Response to Issues – Miscellaneous Agencies and Authorities

80-88 Regent Street, Redfern – SSD 7080

Response to Agency from exhibition of EIS (11 February 2016 to 11 March 2016) and notification of RTS (29 November 2016 to 13 December 2016)

DRAINAGE CONCEPT PROPOSAL ROOF PLAN

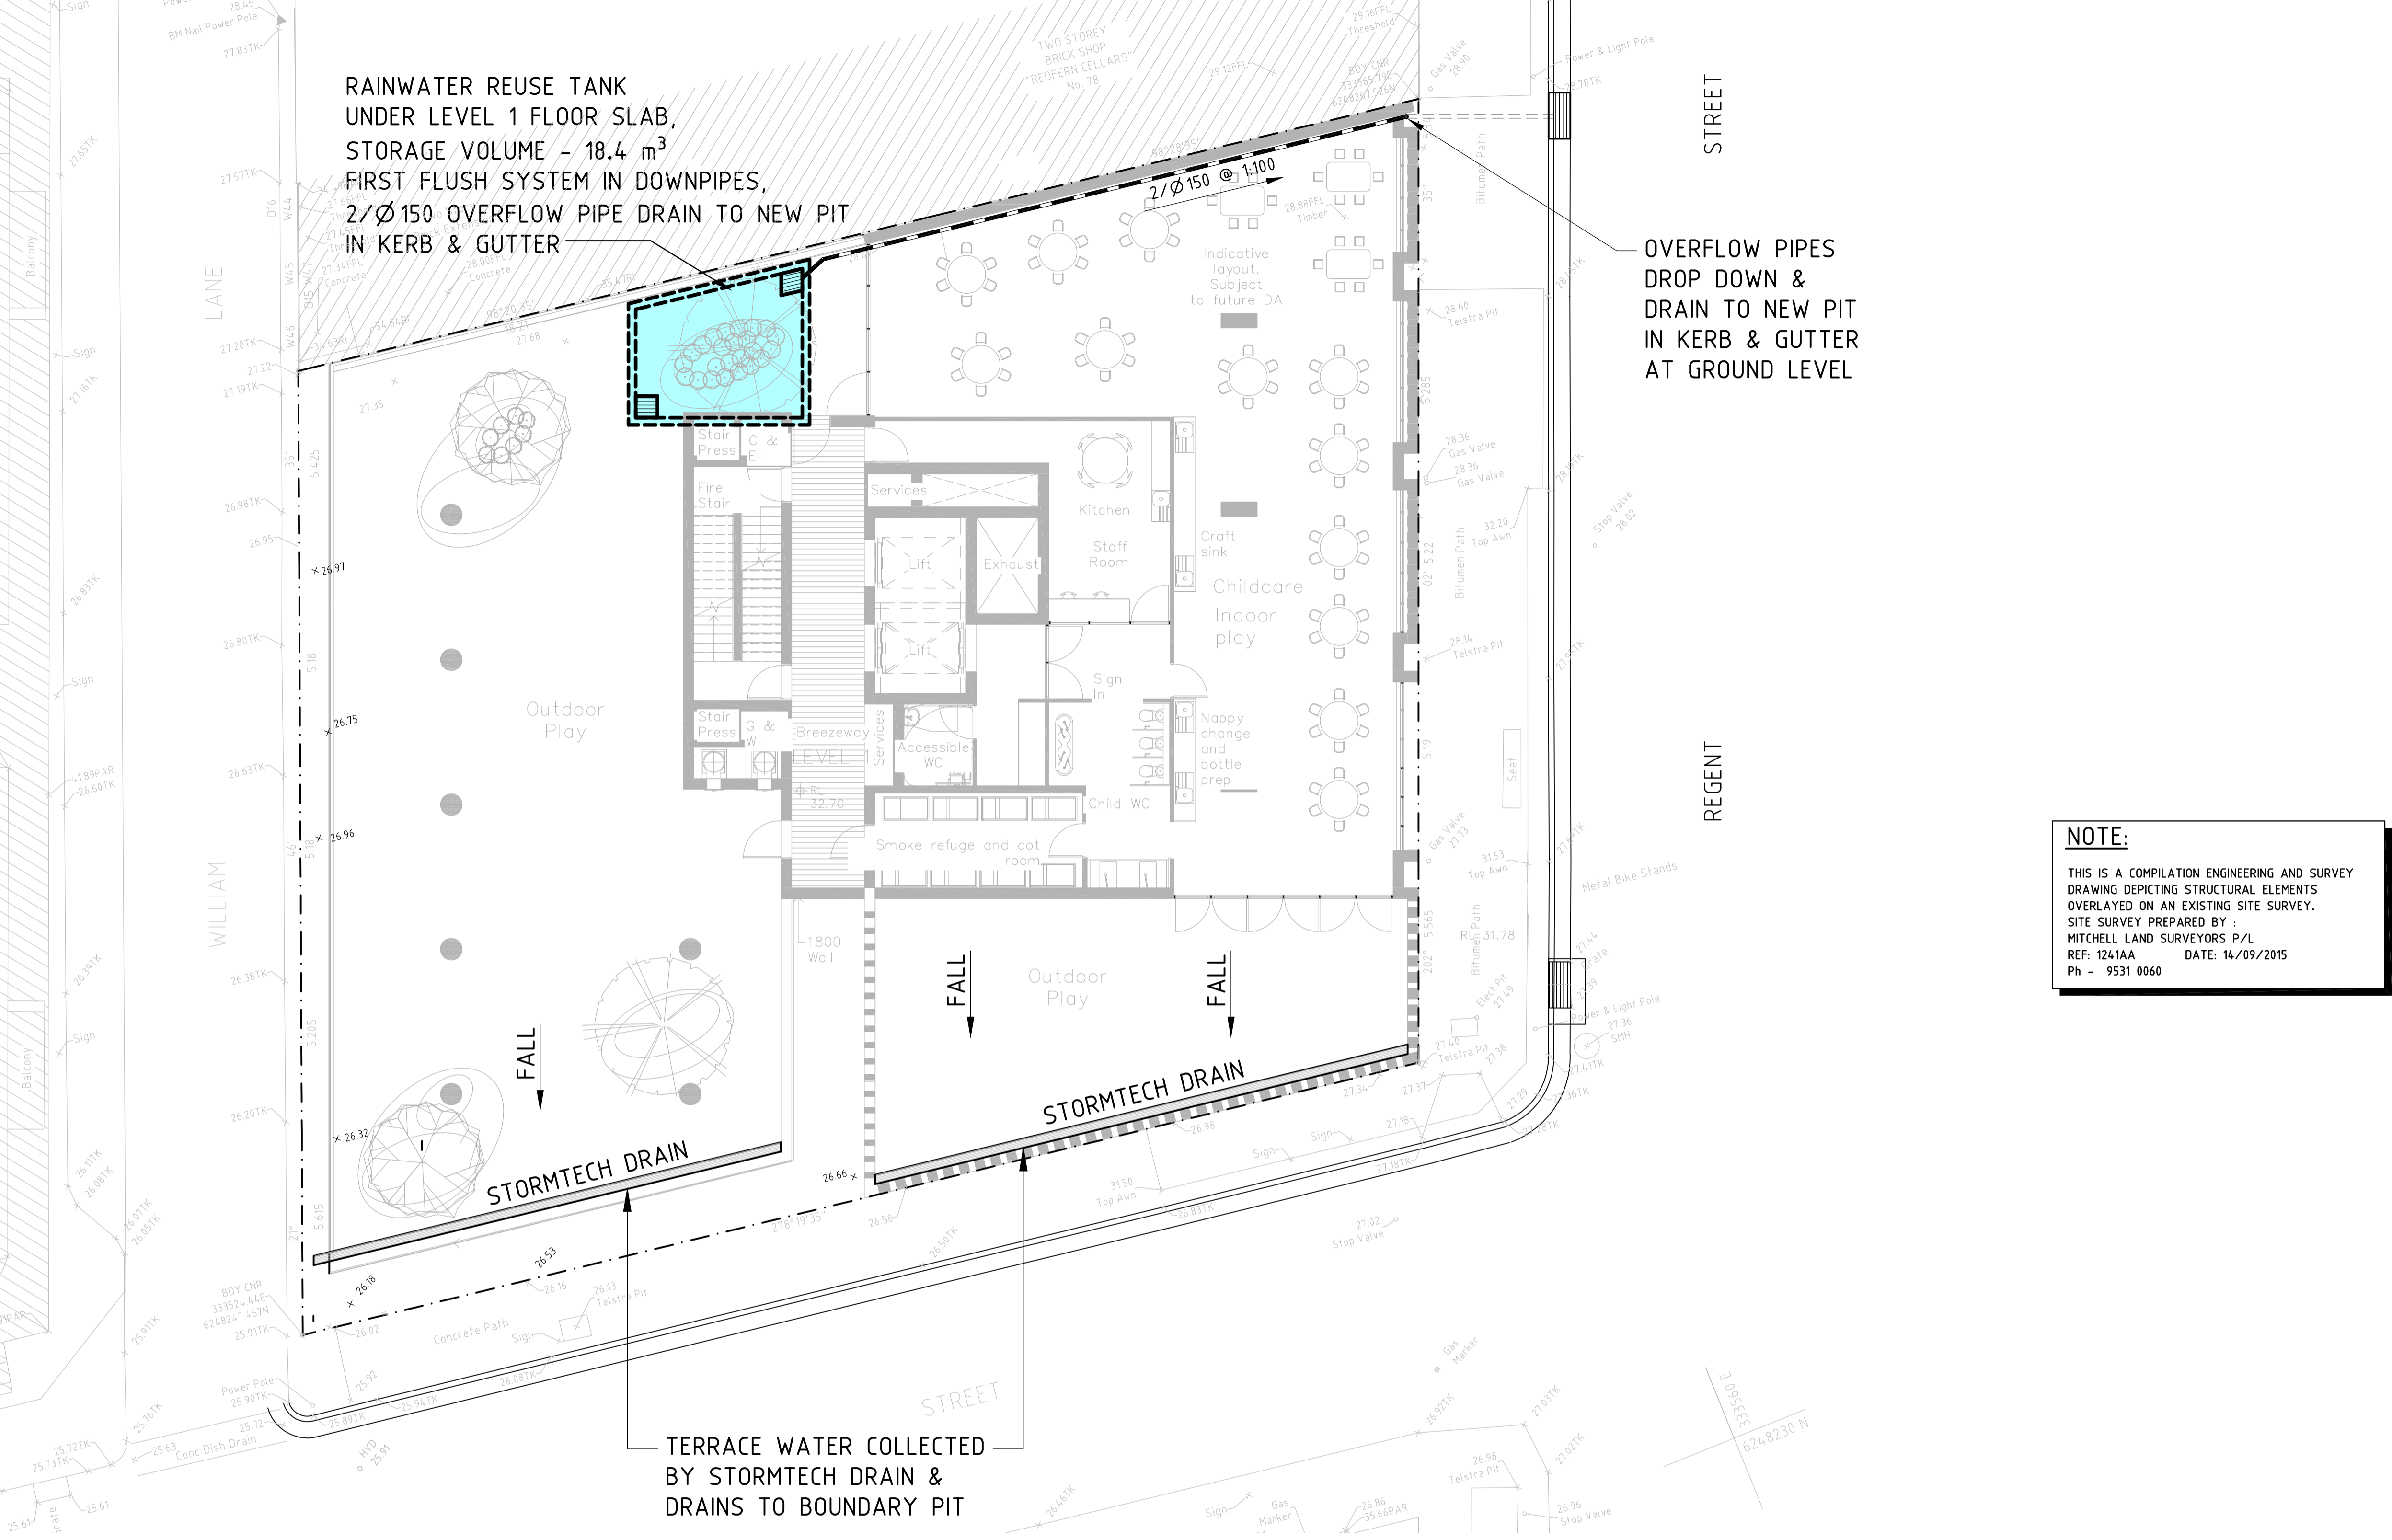
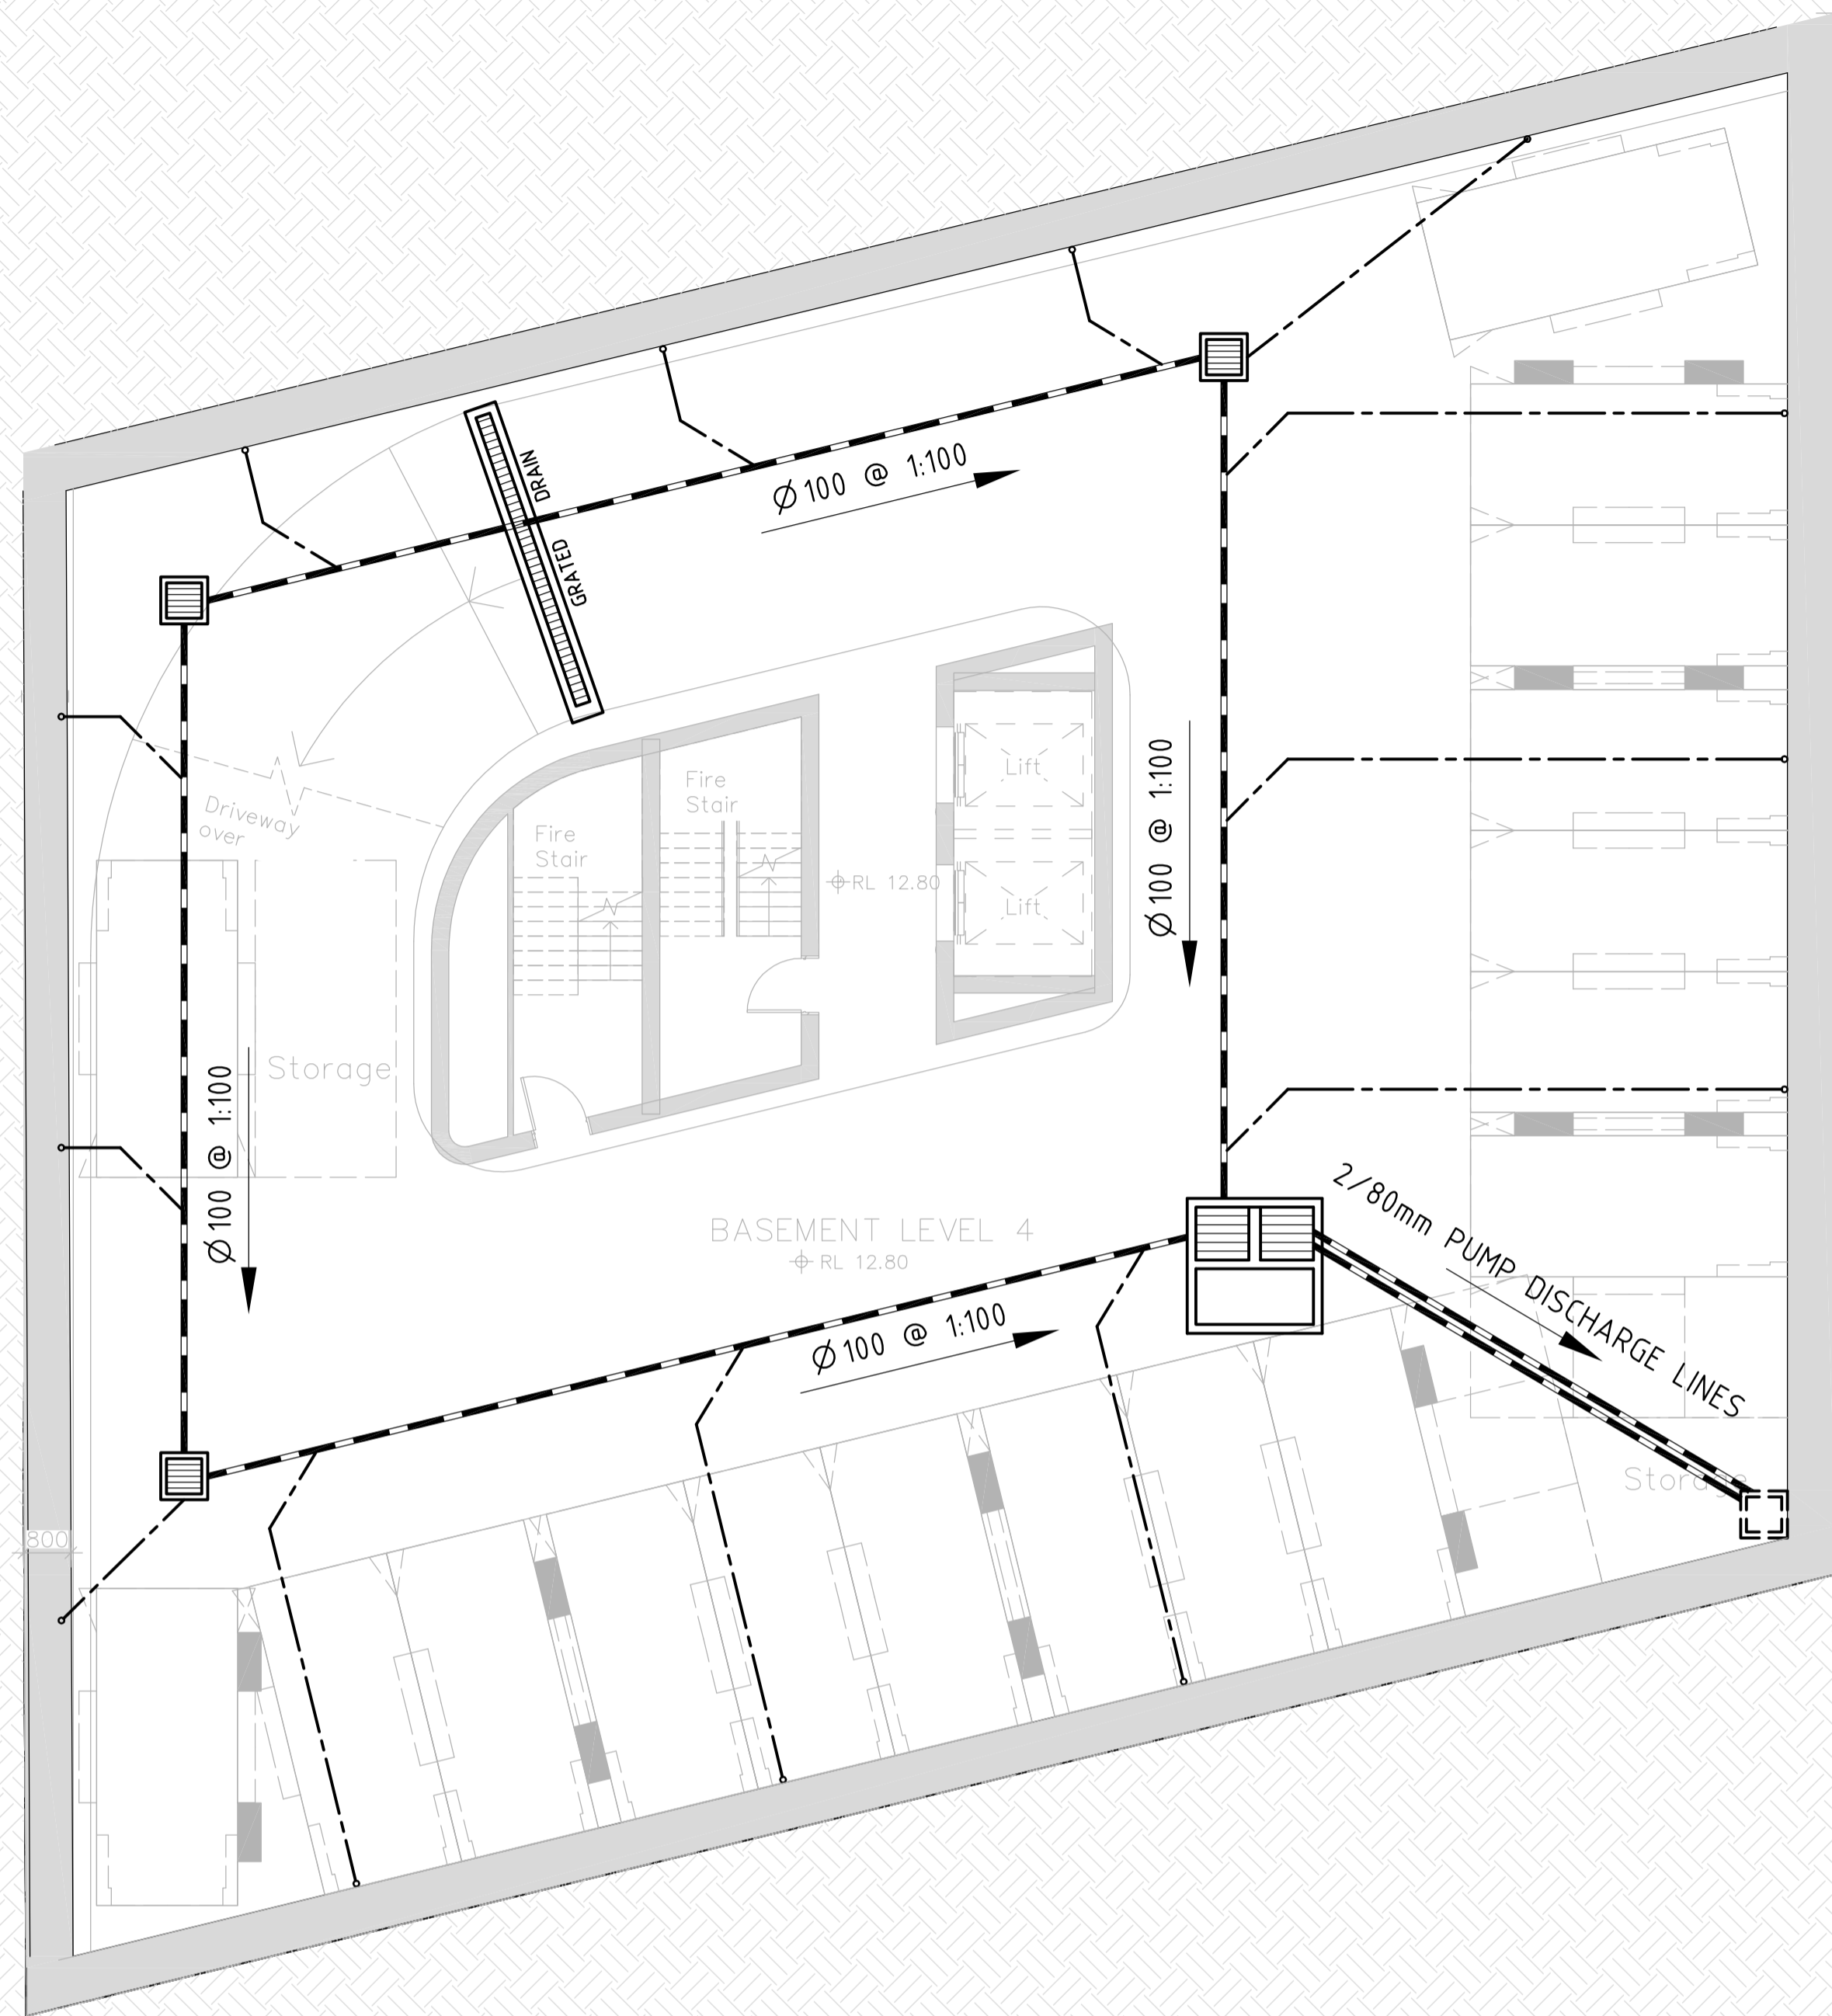
<i>A Road Occupancy Licence should be obtained from Transport Management Centre for any works that may impact on traffic flows on Regent Street during construction activities.</i>				
	<i>Should the post development storm water discharge from the subject site into the Roads and Maritime system exceed the pre-development discharge, detailed design plans and hydraulic calculations of any charges are to be submitted to Roads and Maritime for approval, prior to the commencement of works on site.</i>				
	<i>The developer is to submit design drawings and documents relating to the excavation of the site and support structures to Roads and Maritime for assessment, in accordance with Technical Direction GTD2012/001.</i>				
	<i>The developer shall be responsible for all public utility adjustment/relocation works, necessitated by the above work and as required by the various public utility authorities and/or their agents.</i>
